Our Ref: EN010147

Application by Photovolt Development Partners (PVDP) on behalf of SolarFive Ltd for an Order Granting Development Consent for the Botley West Solar Farm

Advice following issue of decision to accept the application for examination

Photovoltaic Development Partners GmbH
 Kurfürstendamm 52
 10707 Berlin, Germany

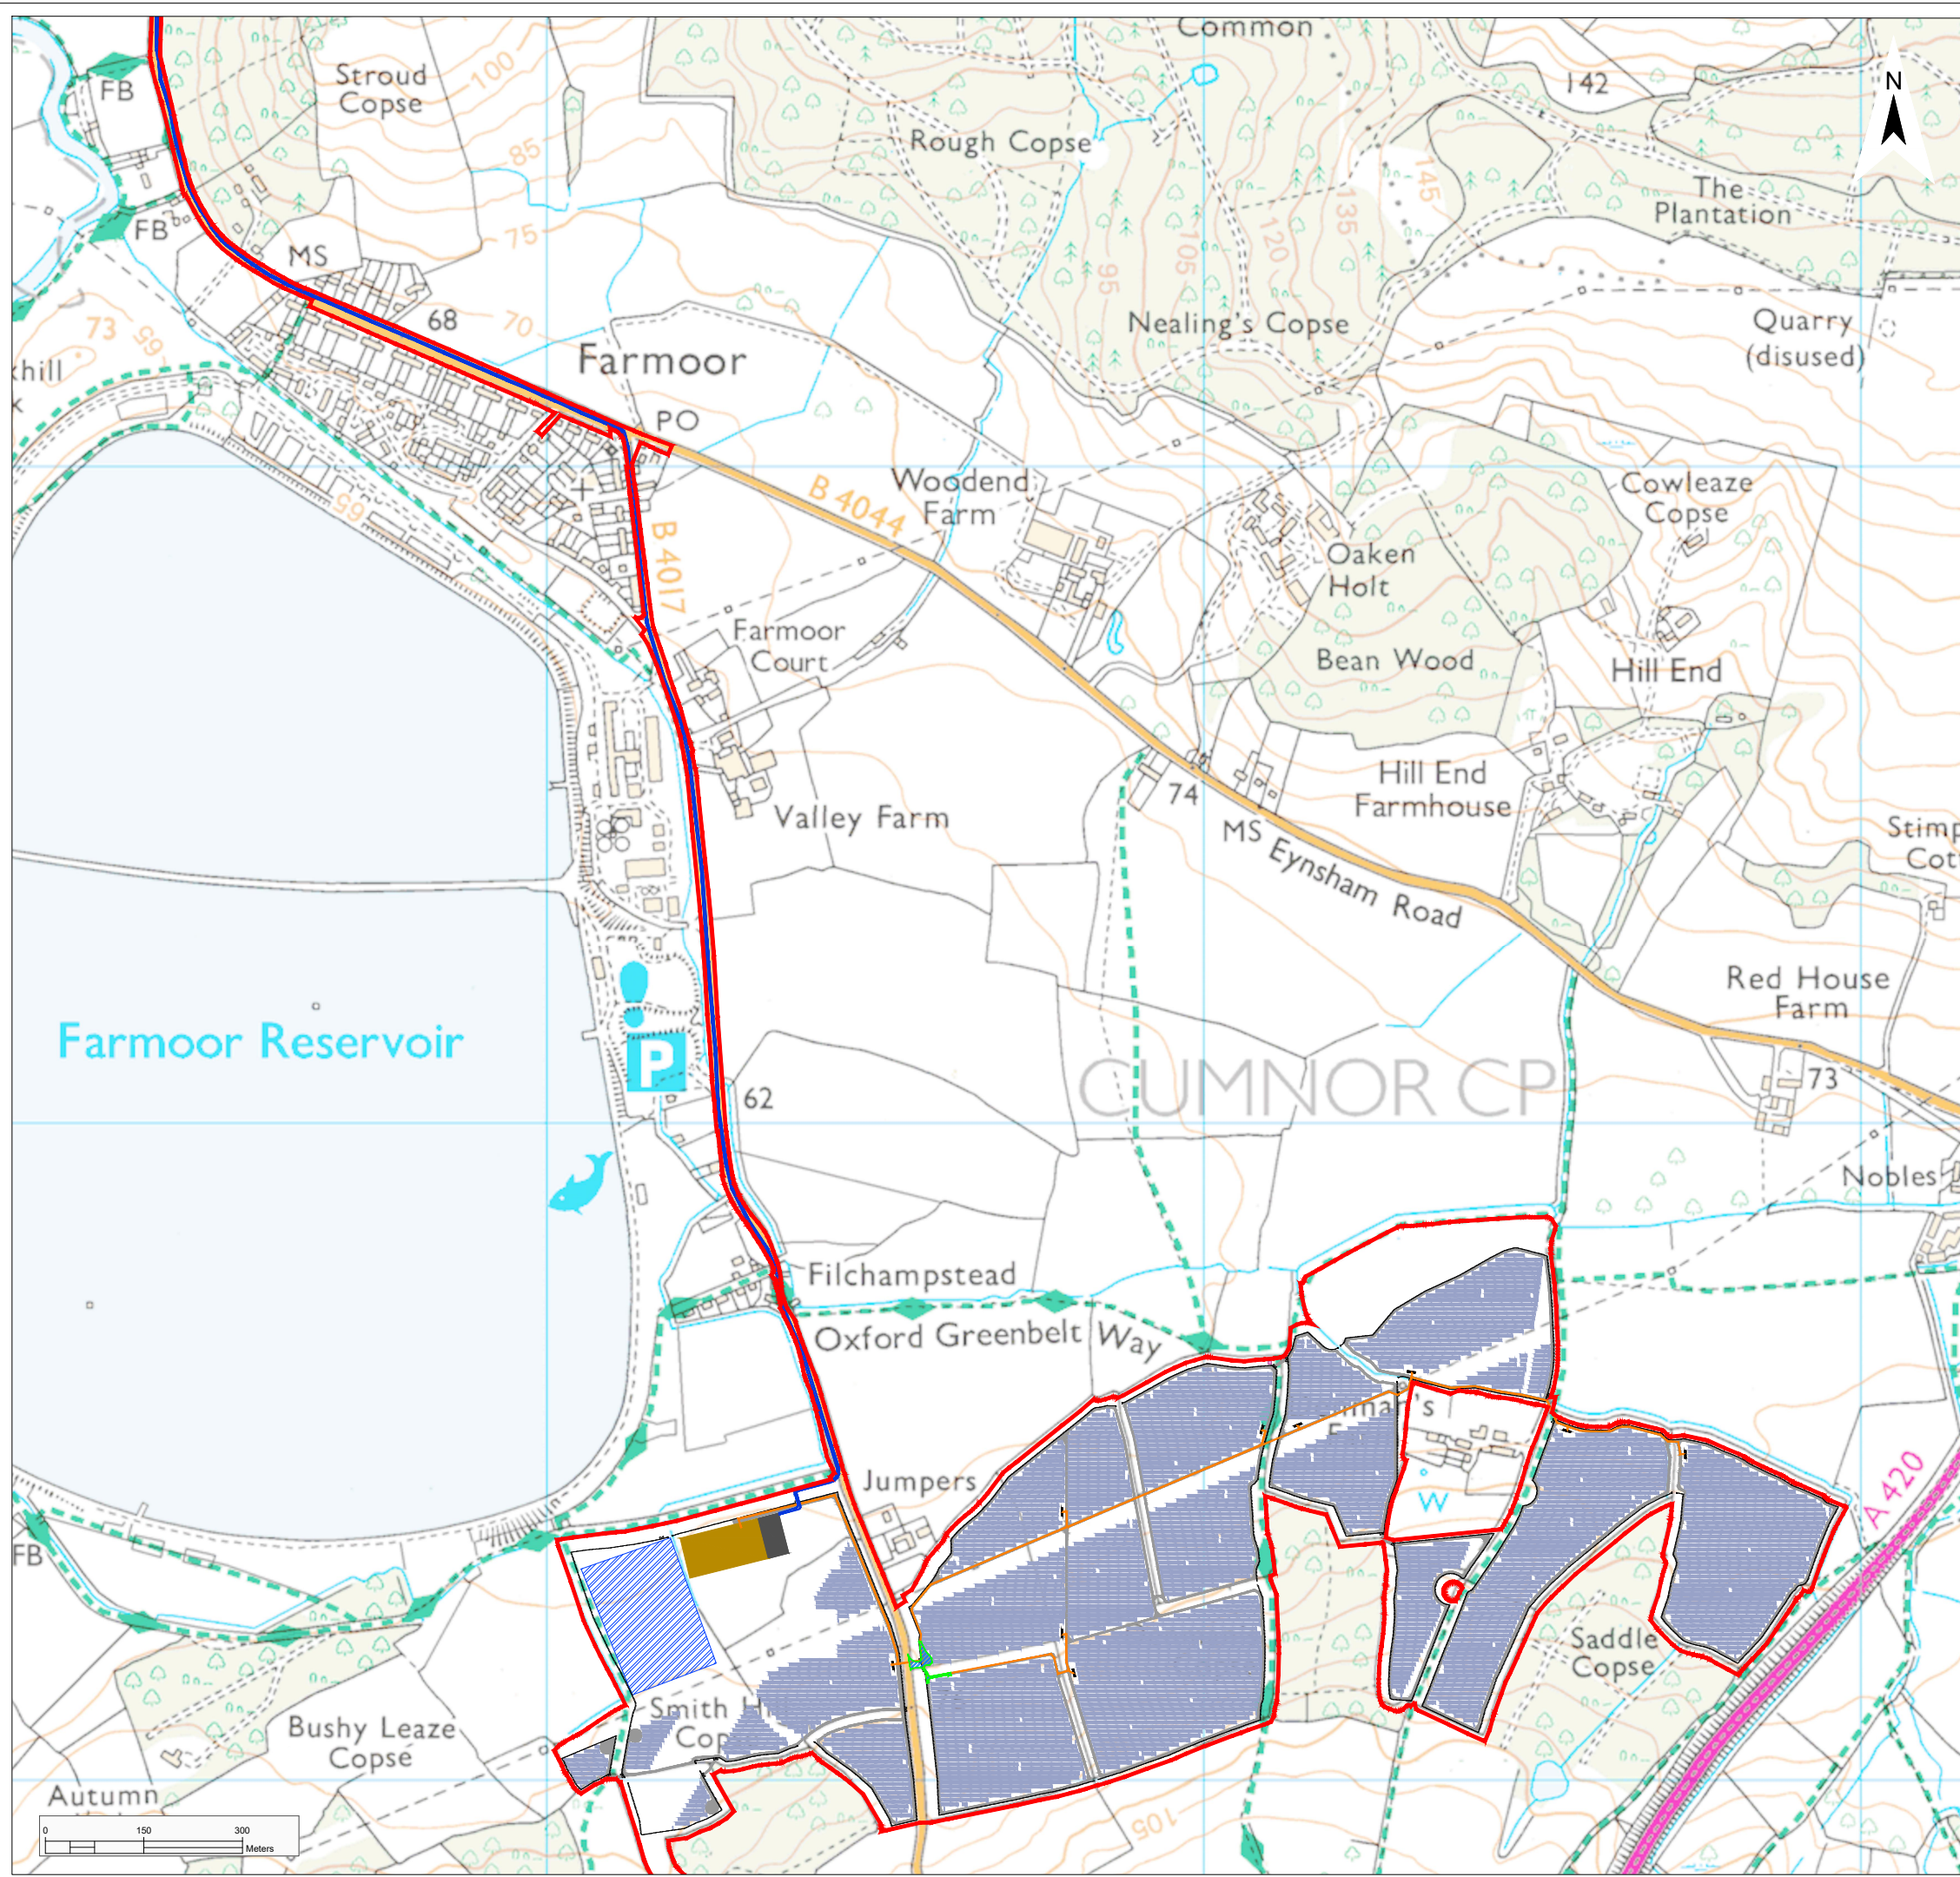
Operational Development Areas Plans (Doc 7.3.2), Landscape, Ecology & Amenities Layer Plan (Doc 7.3.3) and Temporary Facilities Plans (Doc 7.3.4)

The Inspectorate draws the attention of the applicant to APFP Regulation 5 (4A) in relation to these plan documents. The applicant may wish to amend these plans to ensure that the scale being used follows this regulation. For the benefit of the understanding of all parties to a future examination it may be desirable if it was more clearly presented on the plans which areas are within the Order Limits and how the sheet in question fits in the context of the wider site.
